From: Andrew Wood
Sent: 11 October 2019 12:15
To: [REDACTED]
Cc: [REDACTED]
Subject: EP/22/19/PL - Further information request

Existing Proposed Plans elevations dwg.no. 882601 Rev A dated Dec 18

From: Andrew Wood
Sent: 17 September 2019 09:16
To: Mark Holman [REDACTED]
Subject: EP/22/19/PL - Further information request

project	Proposed new walkway at 54-78 Orchard Rd, East Preston		
detail	Existing/Proposed Plans elevations		
drawn	mmh	checked	
date	Dec 18	status	Planning
a1 scale	1:100	a3 scale	1:200
rev	8826 01		A

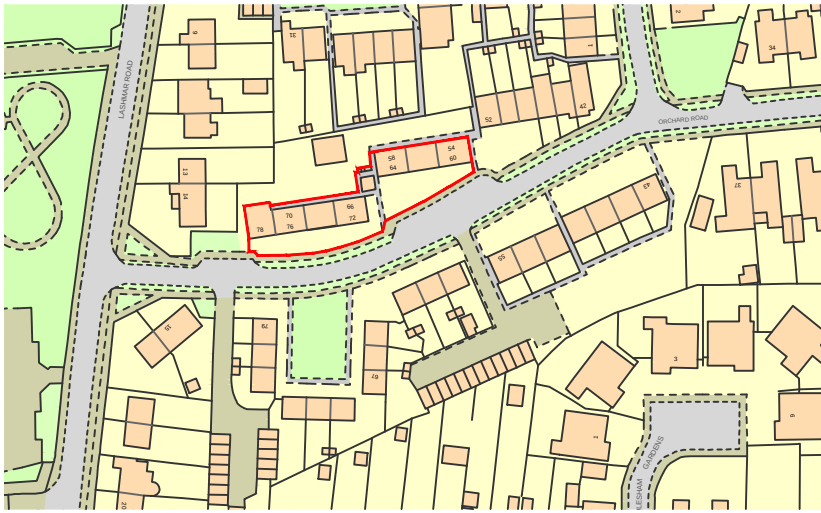
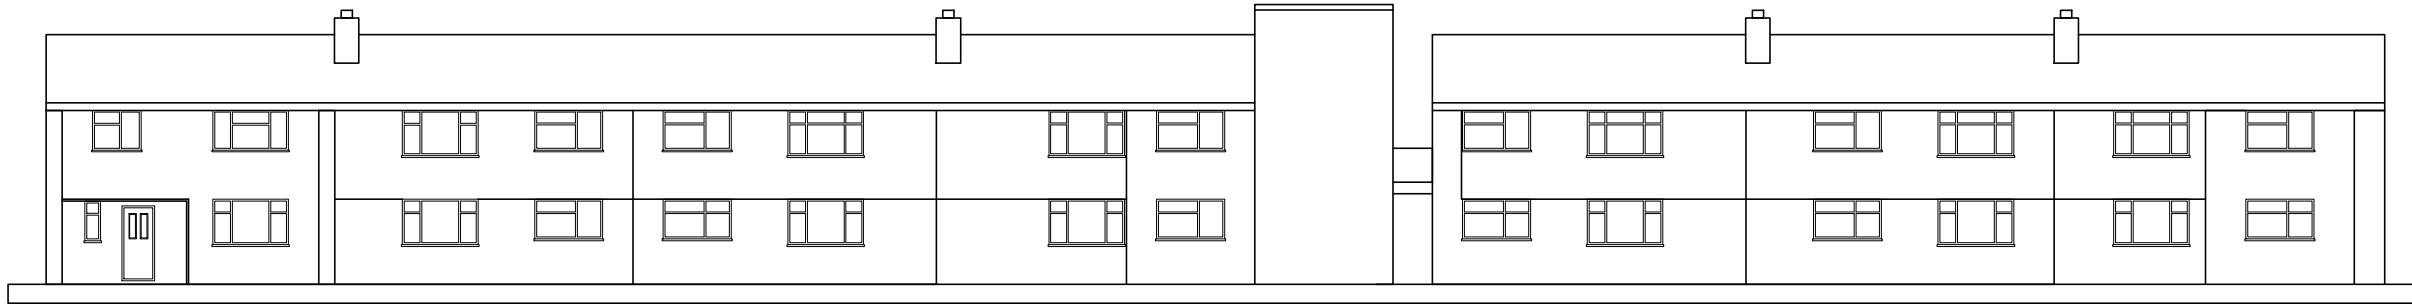
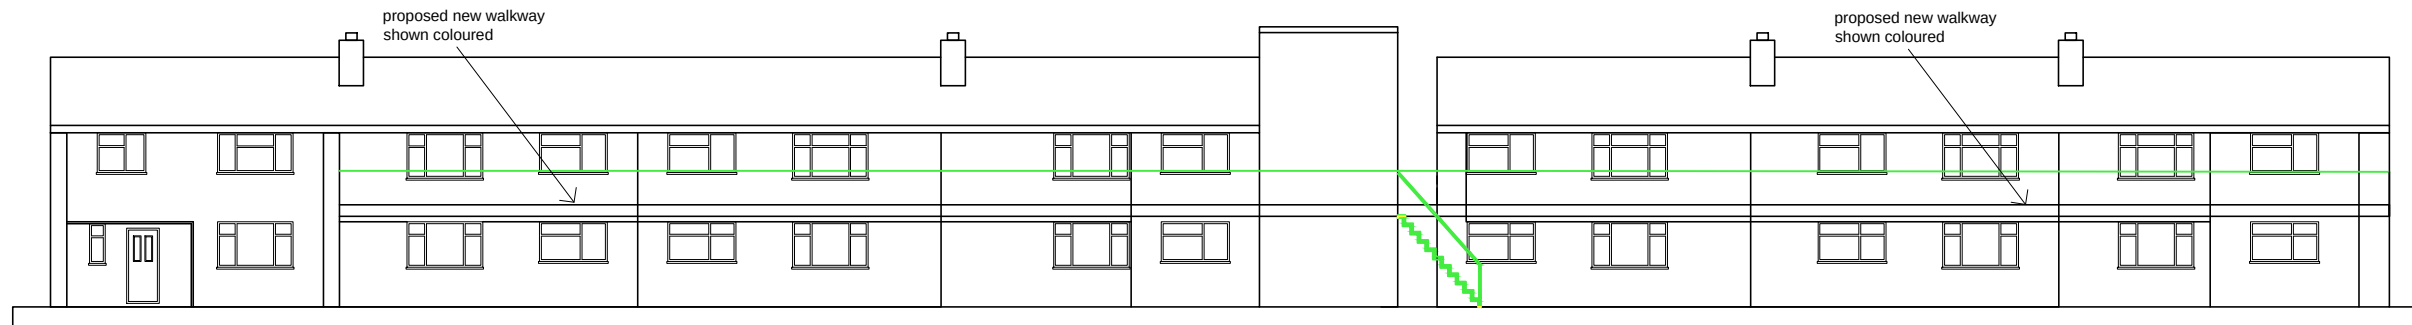
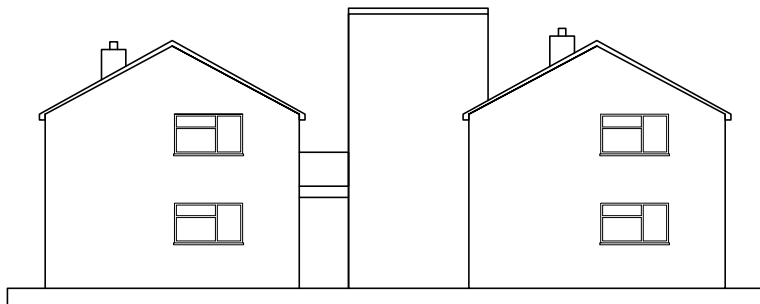
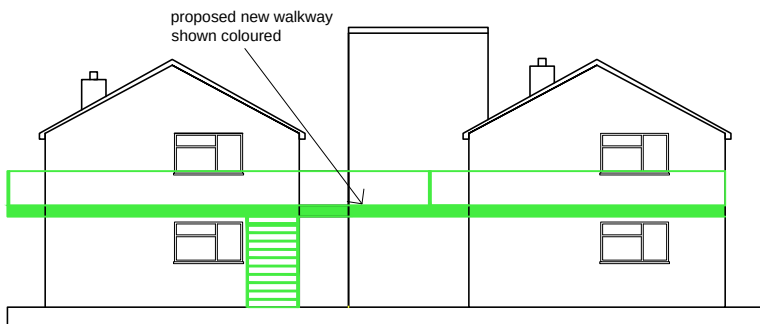
- 1) I require a further updated ASSEM 1 plan as it no longer tallies with the amended plan :

Existing Proposed Plans elevations dwg.no. 882601 Rev A dated Dec 18

I require an accurate elevation plan (i.e. like ASSEM 1) not just an indicative one as in the case of dwg.no. 882601.

- 2) Can you provide a RAL number for the mild steel powder coated (grey) balustrade colour in order to avoid the need for a materials condition which would delay the project further. Please add this to the final accurate elevation drawing.
- 3) As per my previous email I would also like a justification as to why the balcony is being built in the first place . I would assume it is for fire safety however this needs confirming.

We can confirm that the balustrade will be mild steel powder coated(grey) as per our earlier telecom.

block/site plan (A1 1:250 A3 1:500)

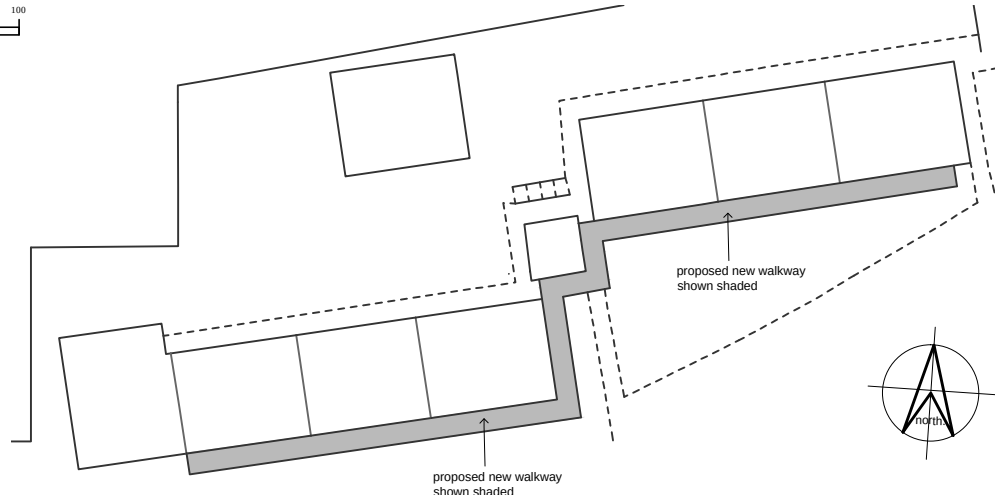
Block/Site Plan shows walkway on front elevation of no. 54/60 only

Please amend plan to remove this.

proposed (East) elevation (A1 1:100 A3 1:200)

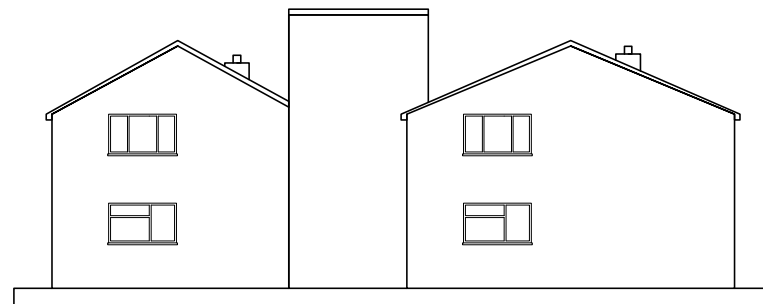
Proposed East elevation shows walkway on East Elevation of 54/60
